Summary of Discussion

Public Meeting, March 23, 2015

3455 Milton Road

DRAFT PLAN OF SUBDIVISION OF PART OF LOT 10 CONCESSION 9
Geographic Township of Cumberland
CITY OF OTTAWA
Prepared by Annis, O'Sullivan, Vollebakk Ltd.

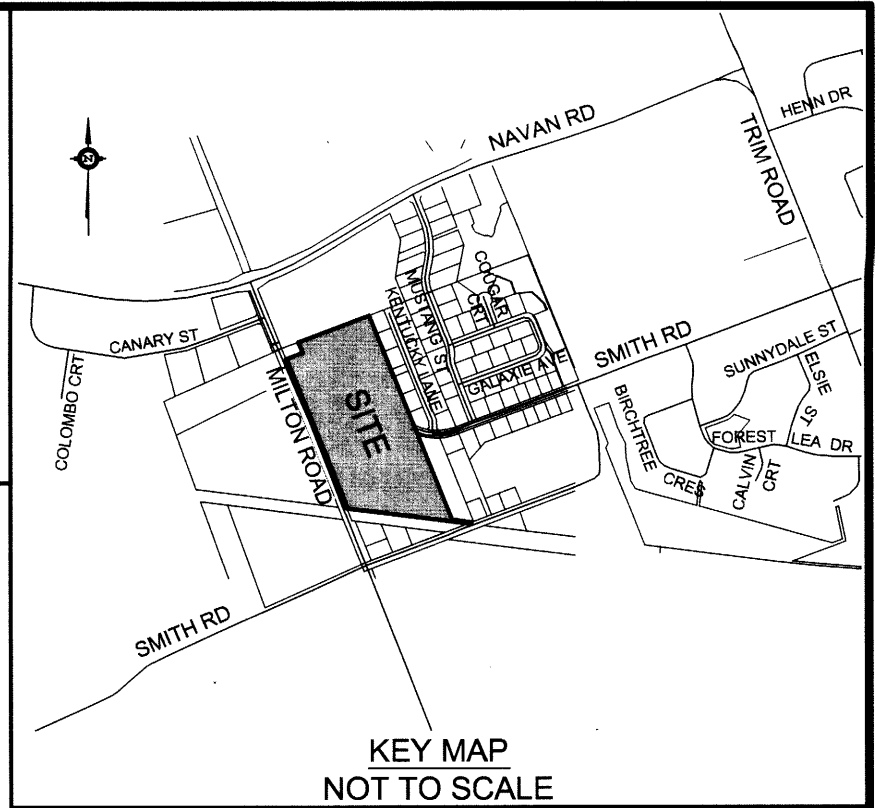
How will erosion and slope stability be addressed, particularly with lots 3, 4, 5 and 21?

Development is proposed to occur outside of the erosion access area and a calculation has been made to determine the no touch zone to ensure where safe development can occur. There are mechanisms available to ensure that these limits are respected such as notices on title or through the zoning.
